Re: Stage 2A (i) City East Zone Substation Project (MP10_0071)

Thank you for your letter of 15 July 2010 about the proposed City East Zone Substation project. Sydney Water has reviewed the proposal and provides the following comments for the Department's consideration.

5.6.2. Longitudinal Section

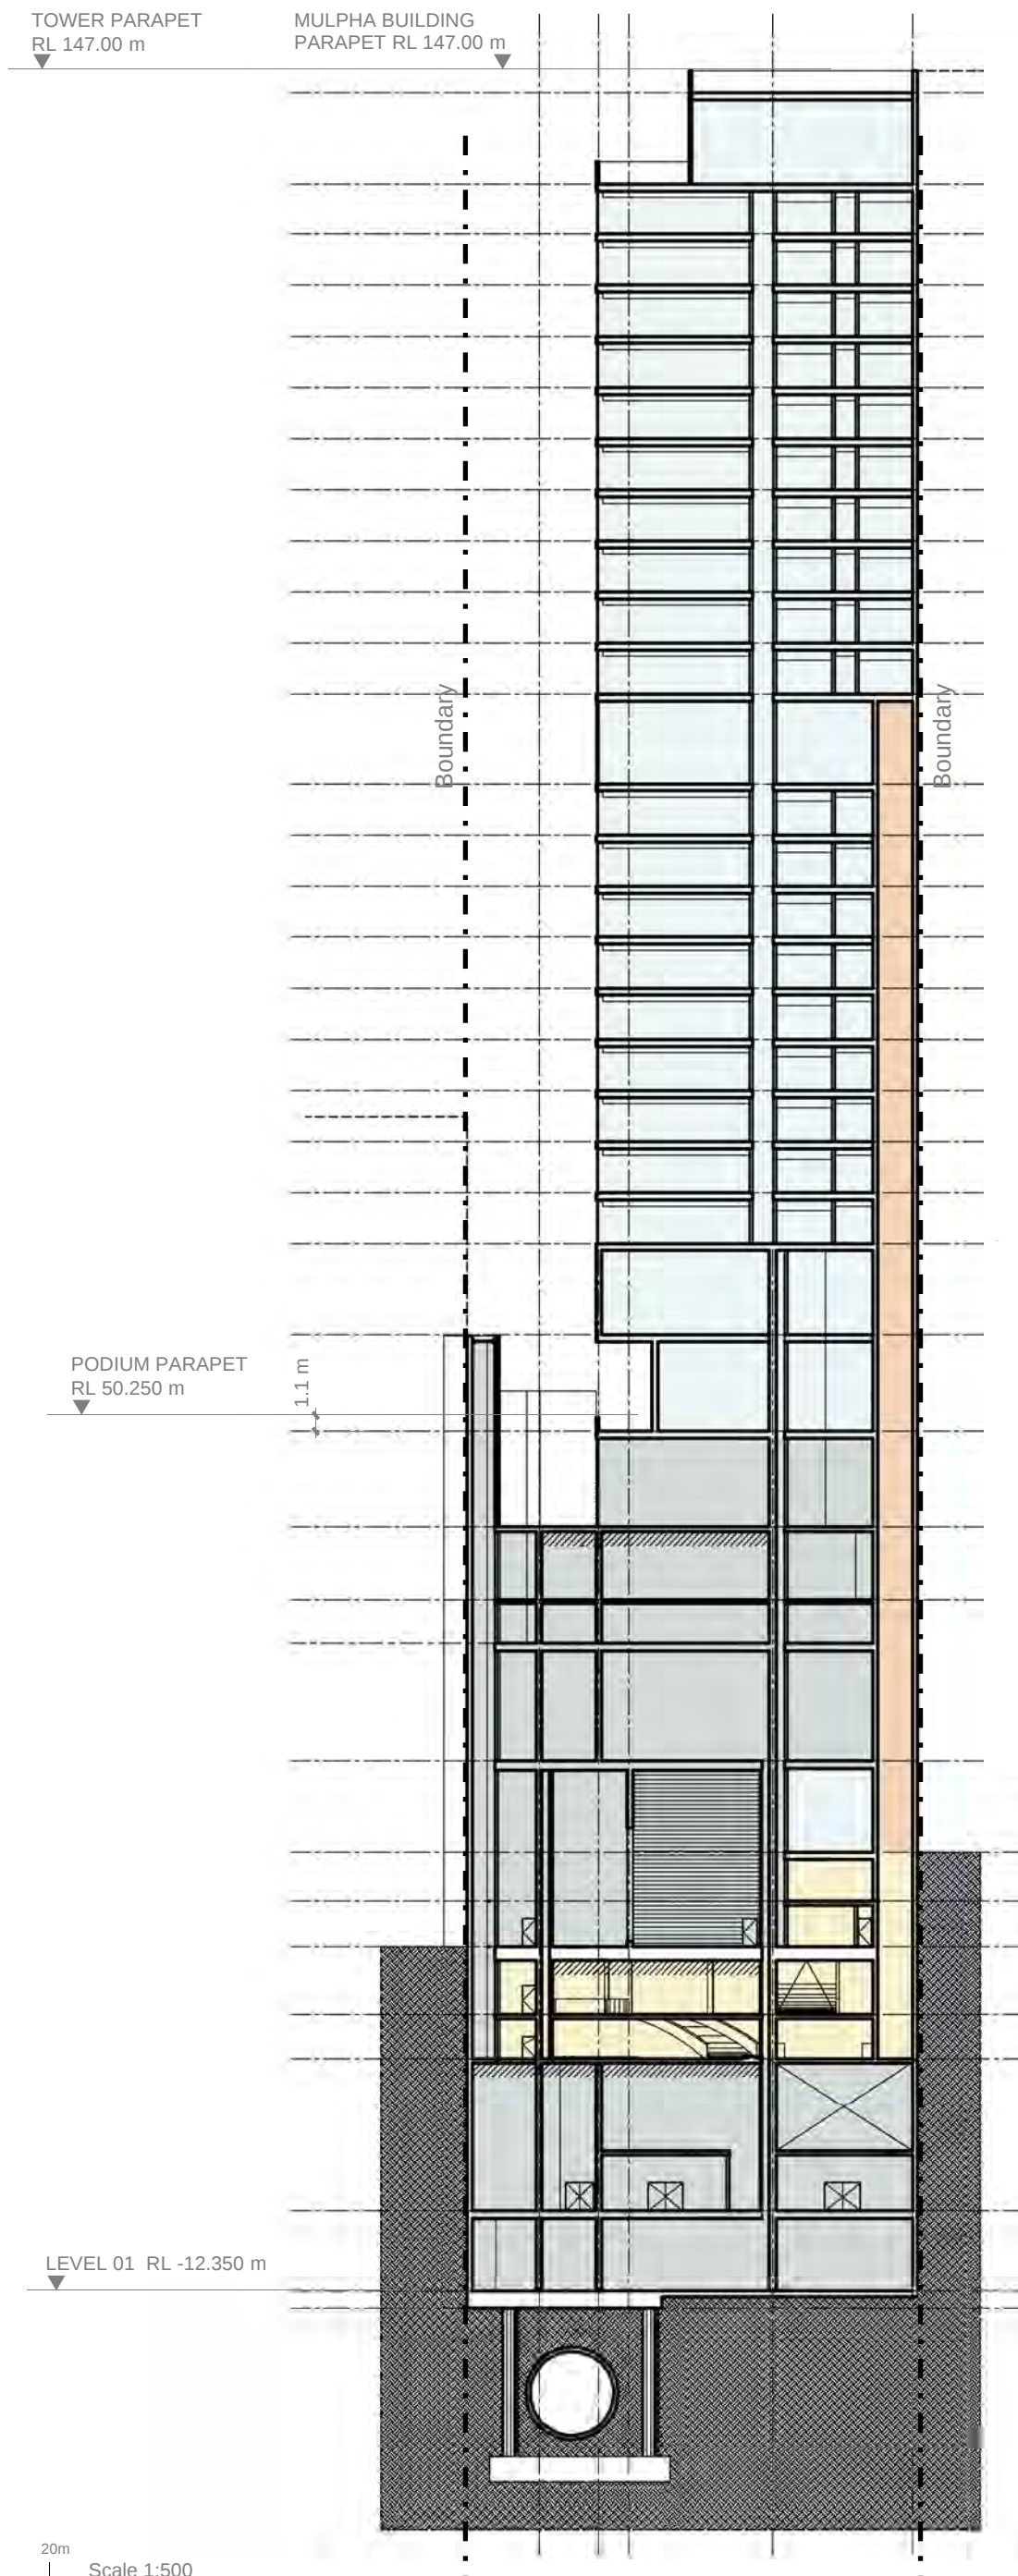
Sydney Water's letter to Energy Australia on 22 June 2010 (attachment one) indicates that the proposed works impacts on Sydney Water critical water and wastewater mains, and the State heritage listed Bennelong Stormwater Channel. Energy Australia will need to meet the requirements outlined in attachment one to ensure that the structural integrity of these assets is not compromised at any stage of the development.

Energy Australia will need to provide more detailed structural assessments at the concept and design stages of the project for Sydney Water's approval, including:

- a plan and long section describing the location and level of Sydney Water's infrastructure in relation to the proposed City East Substation basement excavation and stub tunnel works
- a geotechnical assessment of the potential vibration impacts of the proposed construction works on Sydney Water's infrastructure and any proposed measures to mitigate these impacts.
